**KIRKLEES METROPOLITAN COUNCIL
DEVELOPMENT & MASTER PLANNING SERVICE**

**DELEGATED DECISION FOR PRIOR APPROVAL FOR CHANGE OF USE
FROM COMMERCIAL, BUSINESS AND SERVICE USES TO
DWELLINGHOUSES**

Reference no. 2021/CL/94422/E

Site Address	67, Daisy Hill, Dewsbury, WF13 1LT
---------------------	---

Basement

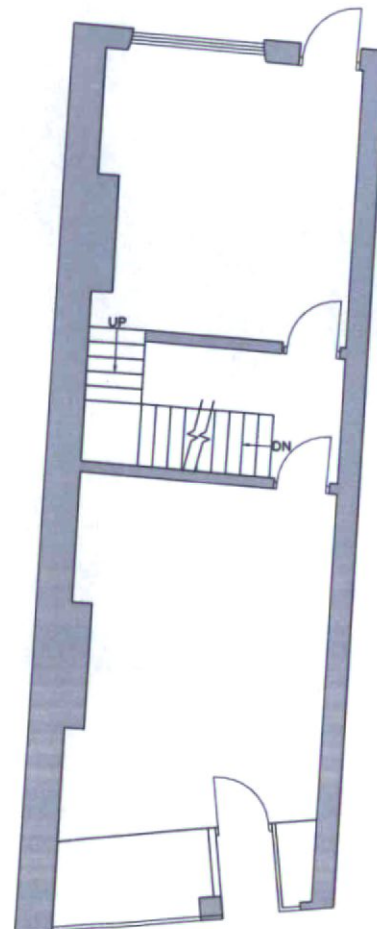
MA.2(2)(f) requires the provision of adequate natural light in all habitable rooms of the dwellinghouses. The proposal sees a bedroom set on the basement level and would be served by a lightwell. No details of the lightwell have been submitted other than its outline shown on the floor plans which are most likely to require planning permission in their own right. Again, due to limited information regarding the lightwell and absence of planning permission, officers cannot be confident that the lightwell will provide adequate natural lighting to the bedroom in the basement. Moreover, the rear room annotated as “snug” on the proposed plan does not benefit from any natural light. Given the definition of habitable room in paragraph X of Part 3, such living space would also be considered to be a habitable room. Finally, the proposed plans indicate rooflights will provide natural light to the living spaces in the attic. As no planning permission exists for these alterations to insert rooflights and no natural light is provided elsewhere, the attic rooms would also not benefit from any natural light. Thus, the proposal is contrary to Local Plan policy LP24b and Chapter 12 of the NPPF the scheme does ensure a good standard of amenity for future occupiers. Procedures as provided in Class W of part 3, paragraph (2(2A)) states that the Local Planning Authority must refuse prior approval if adequate natural light is not provided in all the habitable rooms.

3. The bedroom and snug within the basement of the proposed development shown to be served by the formation of a lightwell and attic study rooms shown to be served by rooflights are only proposed to be provided with natural light by alterations which do not benefit from any existing planning permission being granted. As there is no guarantee natural light can be provided into these rooms it means the Local Planning Authority cannot be satisfied the bedroom and snug in the basement and attic study rooms would be served by adequate natural light. Information regarding the depth, the cover to the well and sections of the lightwell would all be required to determine whether the bedroom and snug could be provided with adequate natural light.. This would harm the amenity of future occupiers. The proposal is therefore deemed contrary to policy LP24 of the Kirklees Local Plan and
